From: Anita Gardner
Sent: 09 November 2018 10:26
To: Karen Parsons
Subject: FW: FG/159/18/PL Bluebird Cafe

Subject: FG/159/18/PL Bluebird Cafe

1. I am unclear as the exact number of covers proposed. Is the total number of covers 235? There is slightly conflicting information in the application documents and I would just like to clarify the exact numbers.

01  
2002  
PROPOSED GROUND FLOOR PLAN  
Scale: 1:100

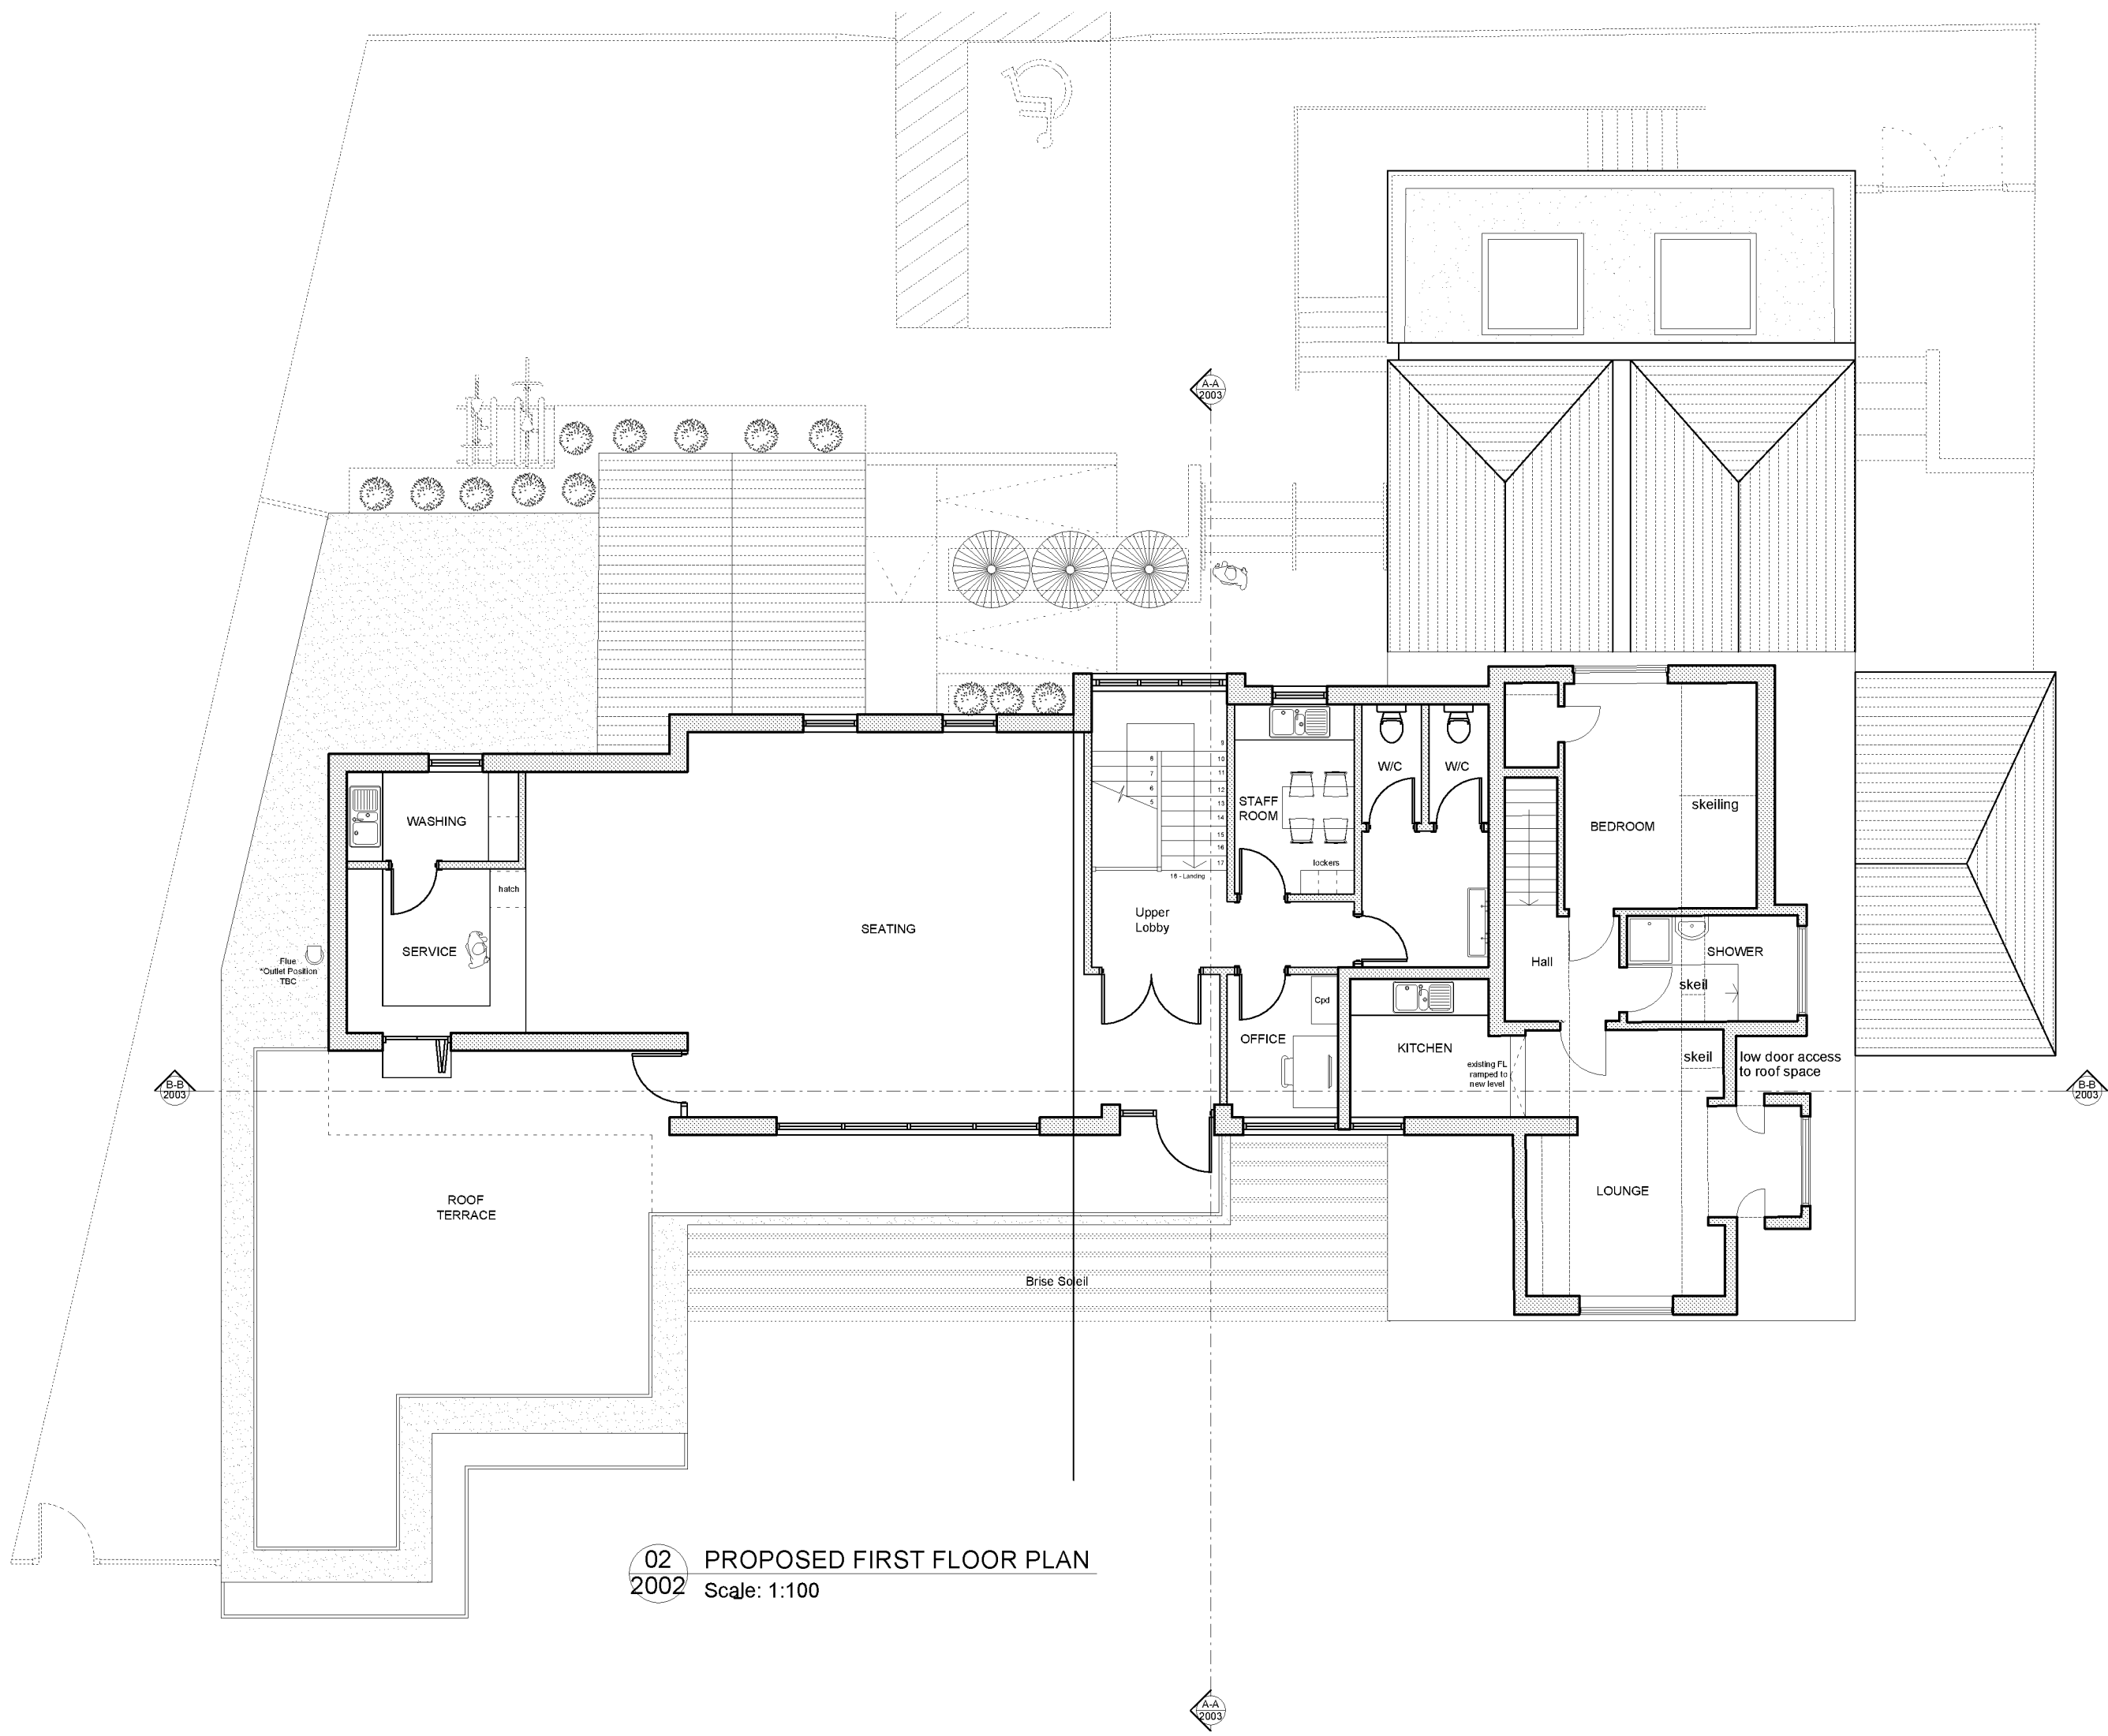
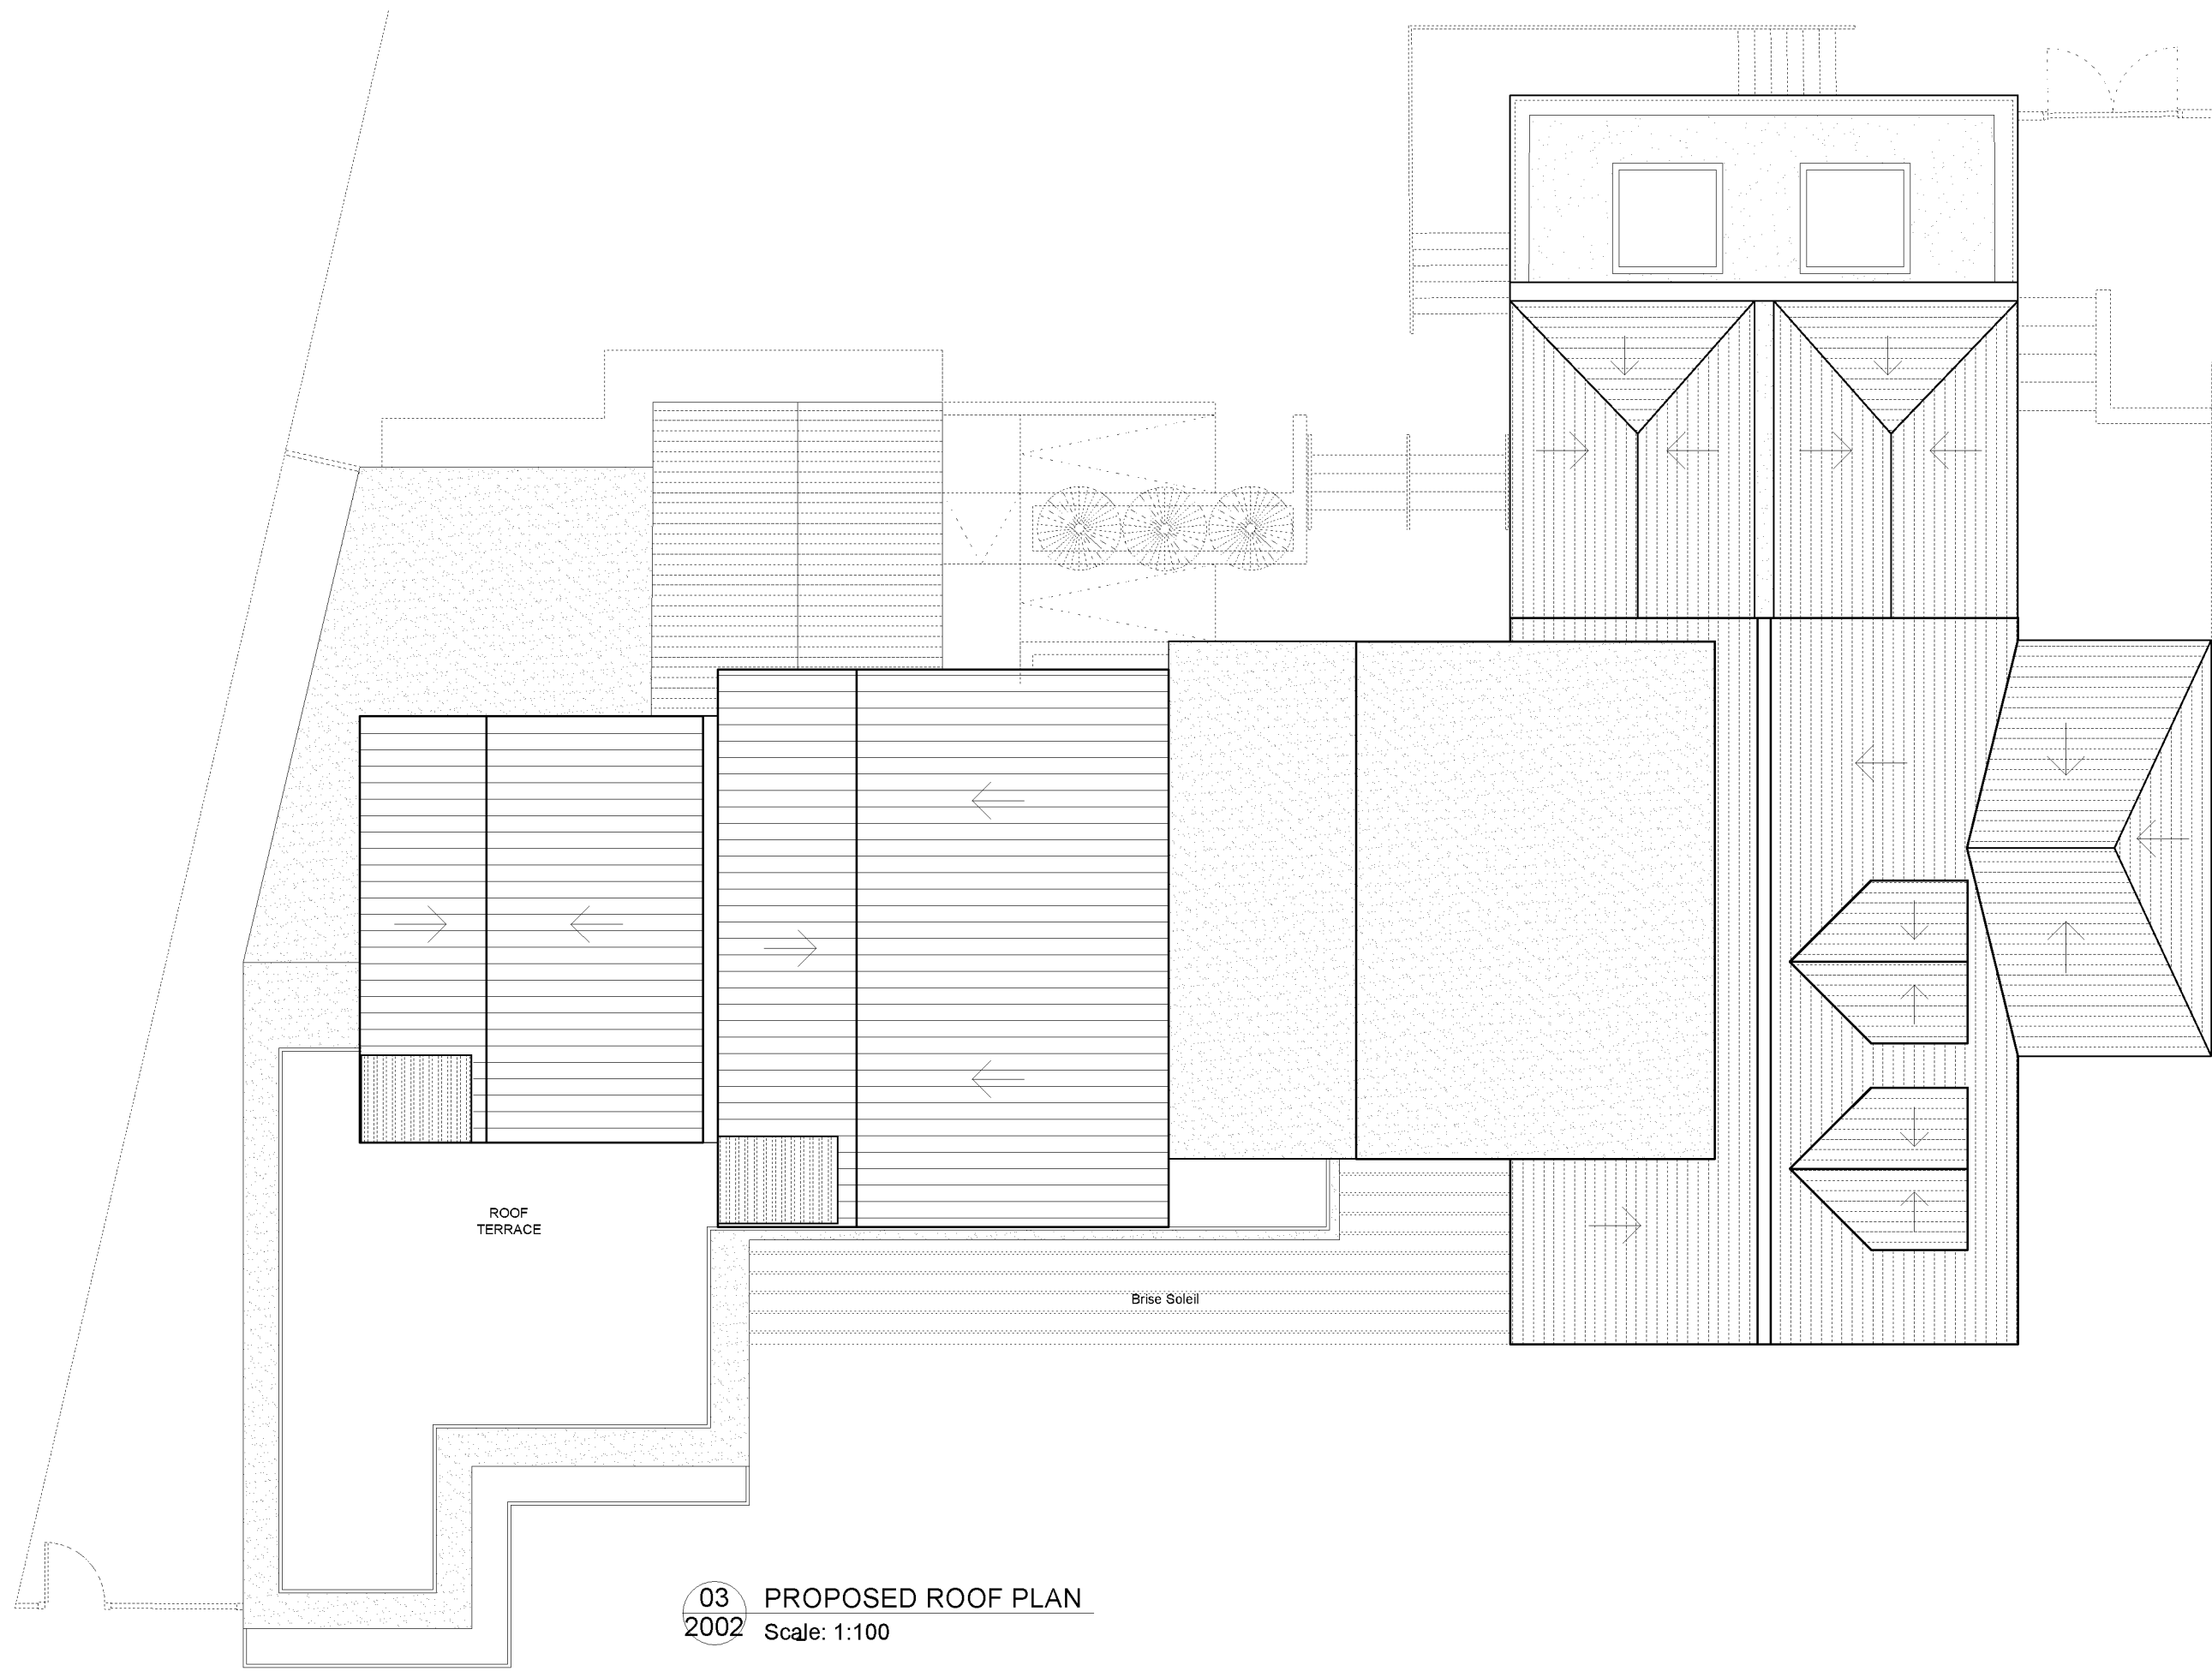
2. Sanitary provision: If the total number of covers is 235 the sanitary provision is insufficient and staff do not appear to have been considered. Please refer to Arun's Sanitary Provision Requirements document: <https://www.arun.gov.uk/download.cfm?doc=docm93iim4n11788.pdf&ver=11779>
